APPROVED - SECOND FLOOR PLAN PL002 REV P02

PROPOSED AMENDED LAYOUT

Summary of Changes

Eighth Floor Plan

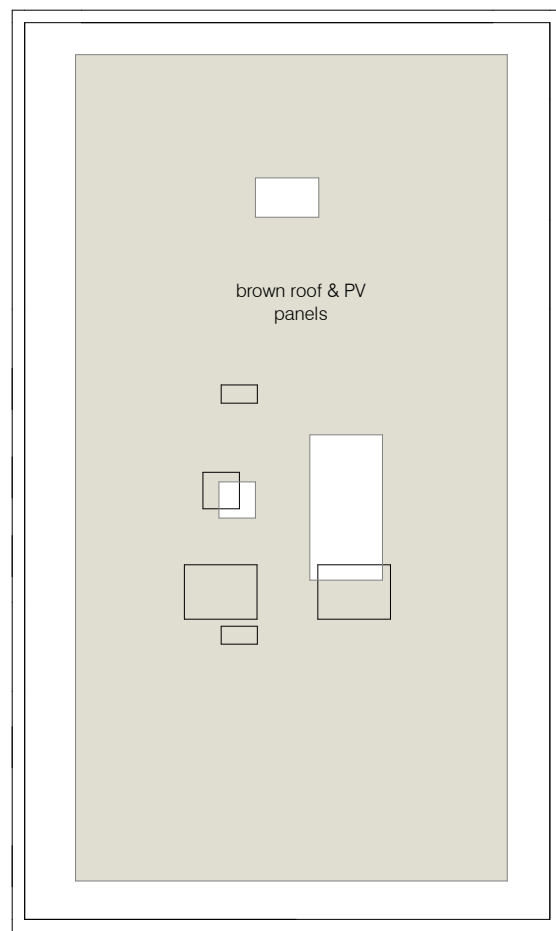
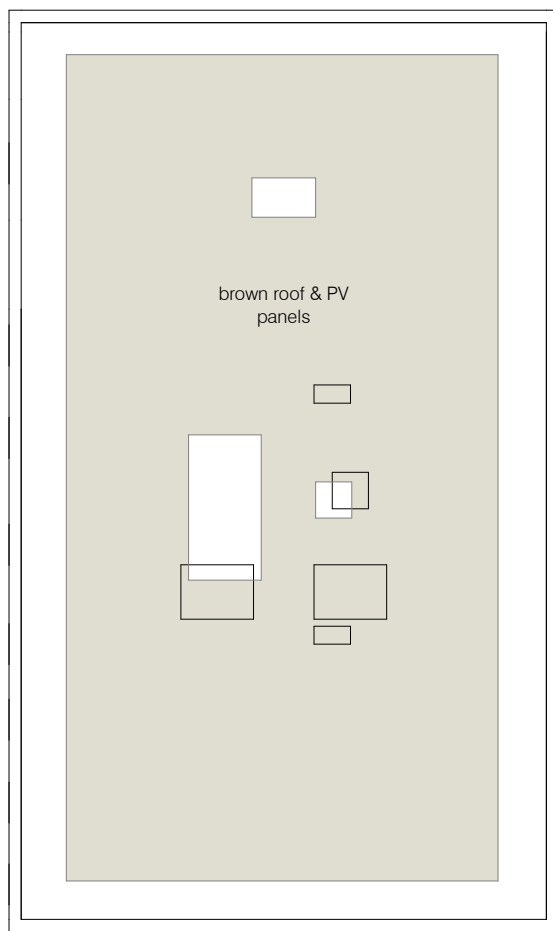
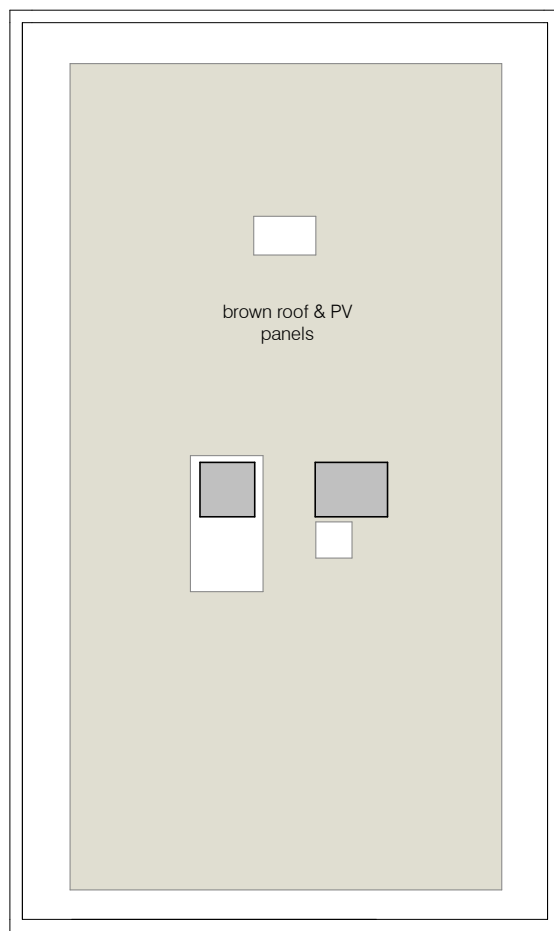
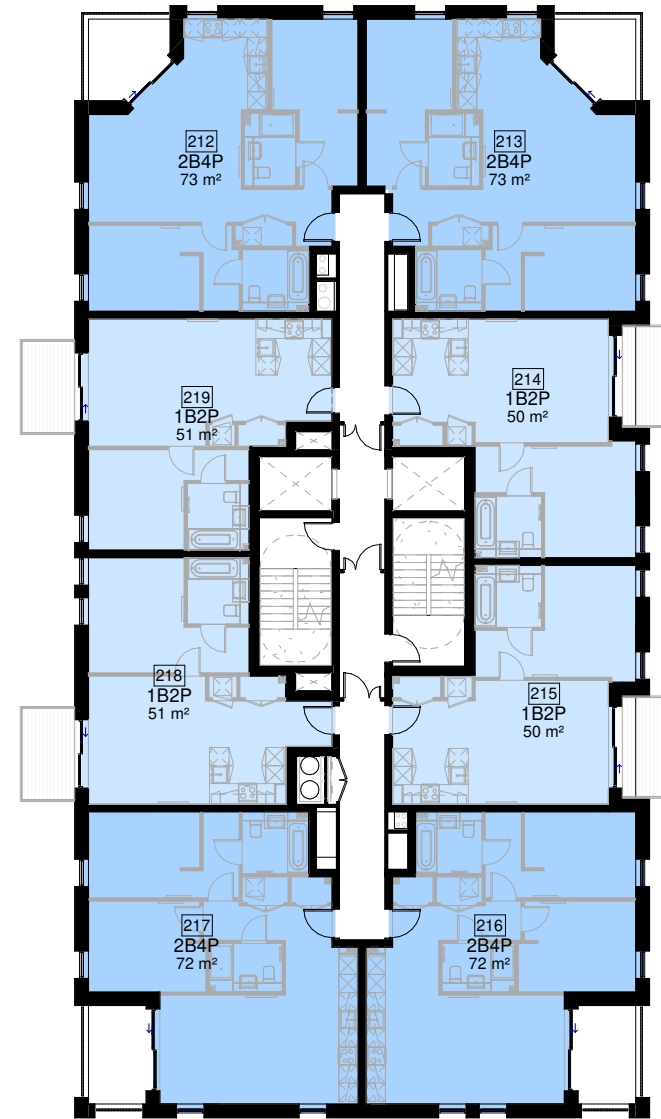
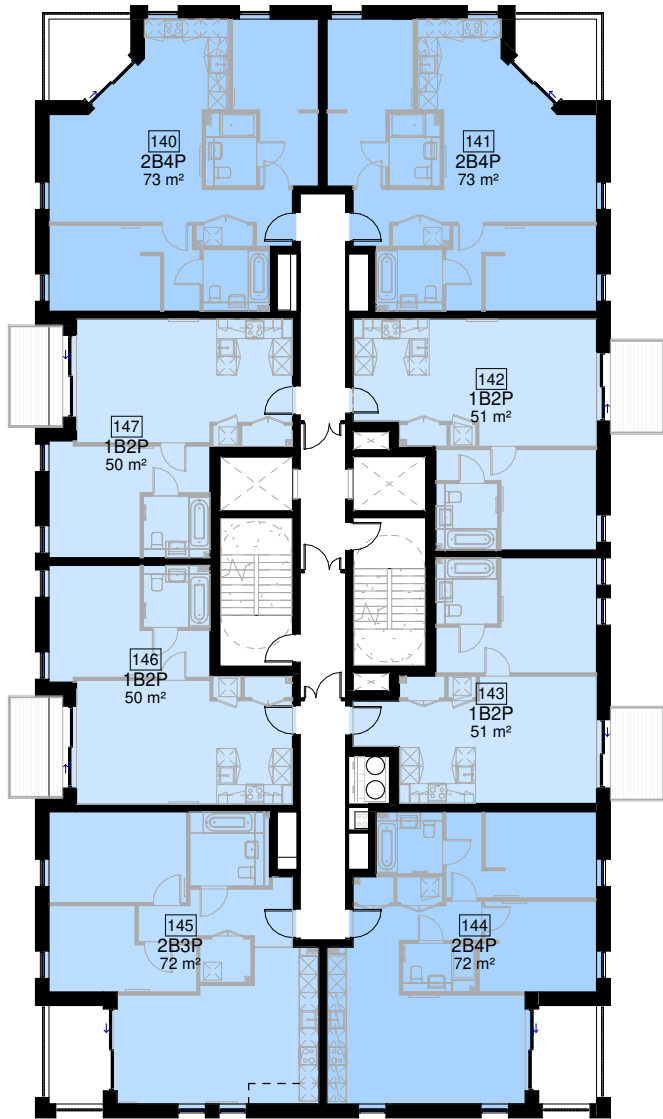
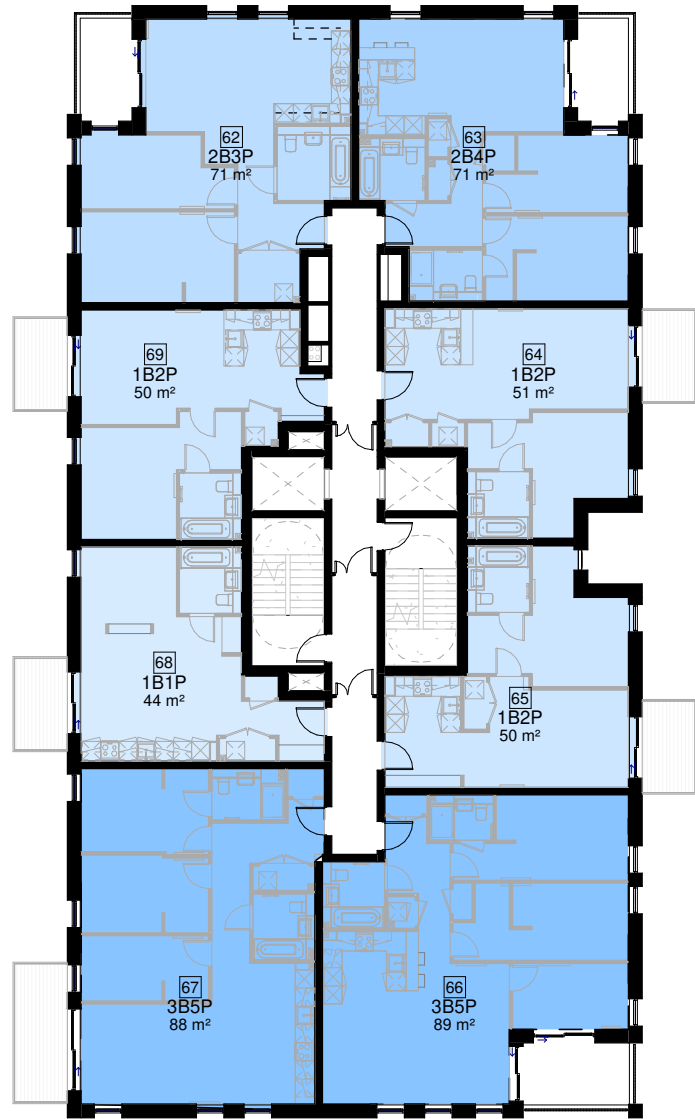
1. Second escape stair added to all cores to provide a secondary means of escape for all residents in the event of a fire. Adjacent homes, risers etc all adjusted to suit.
2. Nominal changes to balconies and facade to ensure that internal flat layouts retain compliance with future fire regulations and ensure escape past hob distances are reduced where possible as advised by JGA Fire.
 - Note - overall change in occupancy is required to allow for the additional stairs to be added. Generally this is done by a reduction of 1B2P homes to 1B1P homes. There is no proposed change to the number of family sized dwellings.
